REQUEST

Current Zoning: N1-A (neighborhood 1-A)
Proposed Zoning: N2-A(CD) (neighborhood 2-A, conditional)

Approximately 14.85 acres located on the northeast side of Paw Creek Road, east of Little Rock Road.

The petition proposes the development of up to 127 duplex, triplex, and quadruplex dwellings. The property is currently the site of 1 single-family dwelling.

RZ-2

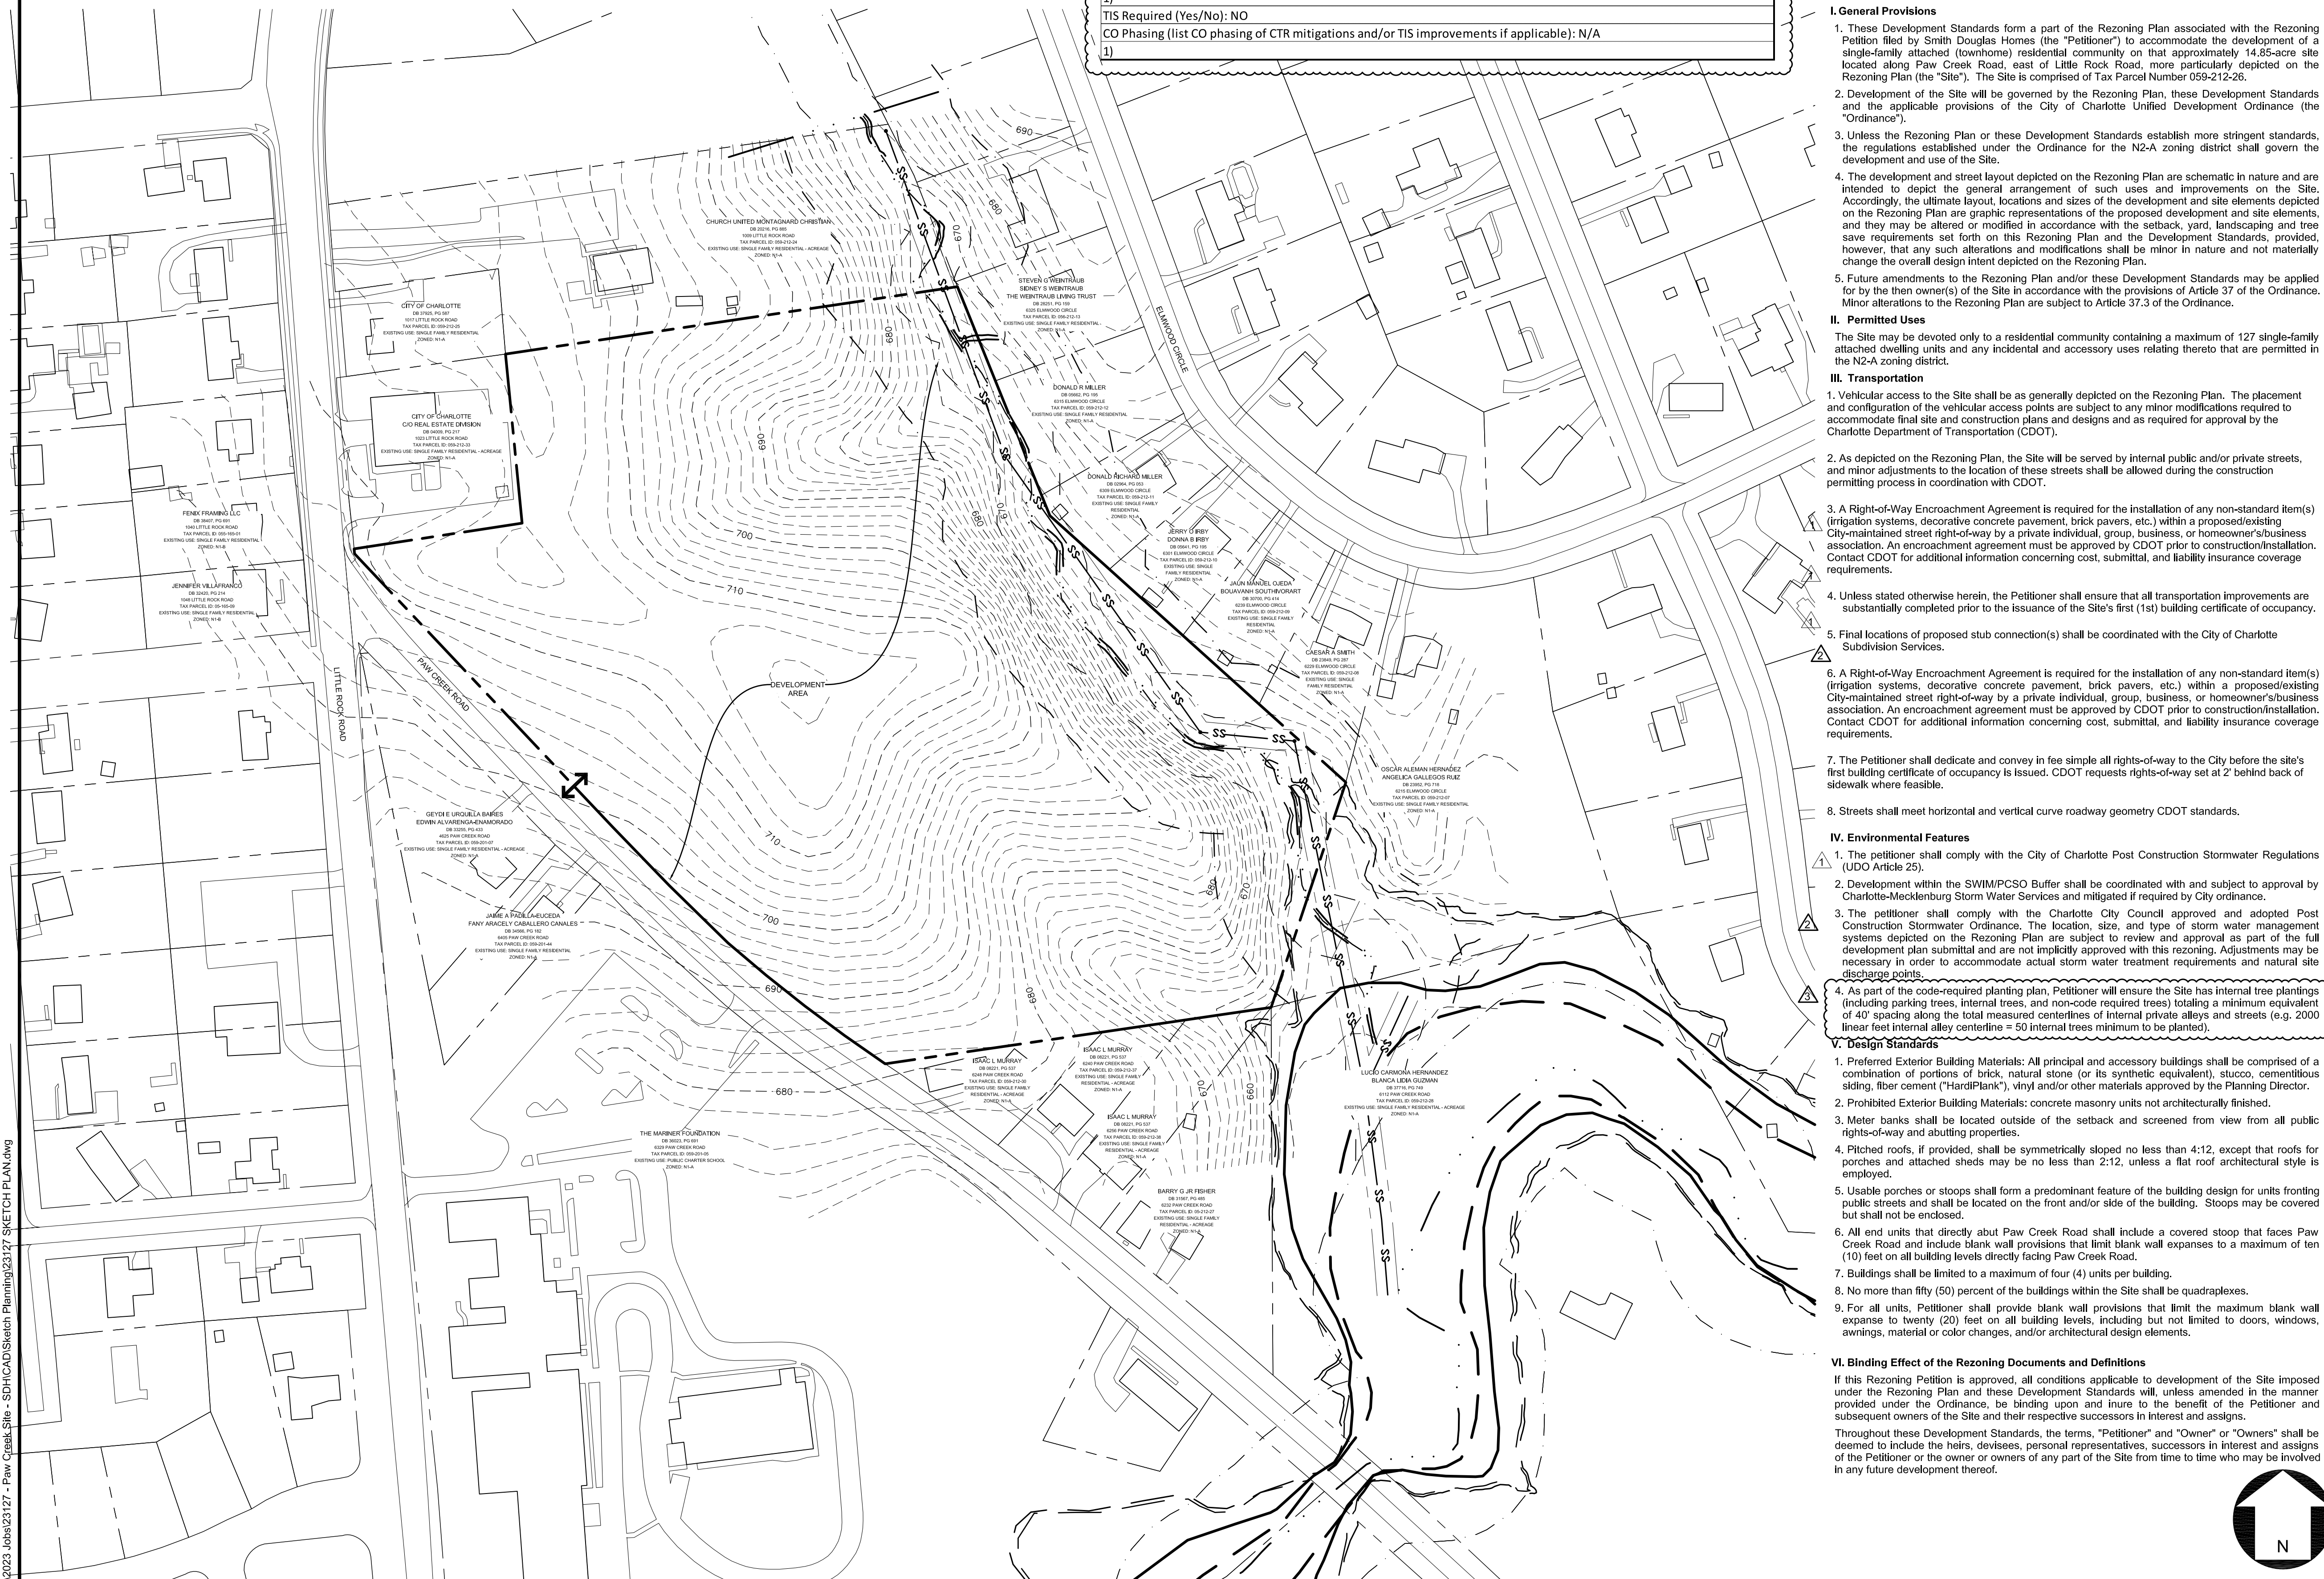
7. Comprehensive Transportation Review (CTR). The petition's zoning falls within the low intensity development which based on the 917 daily trips will trigger Tier 1 (3 mitigation points) for multimodal assessment. The petitioner shall review and assess the publicly accessible pedestrian network within ¼ mile walking distance of the site to identify multimodal infrastructure to meet the Tier 1 (3 mitigation points) for multimodal assessment. **To be addressed in permitting**
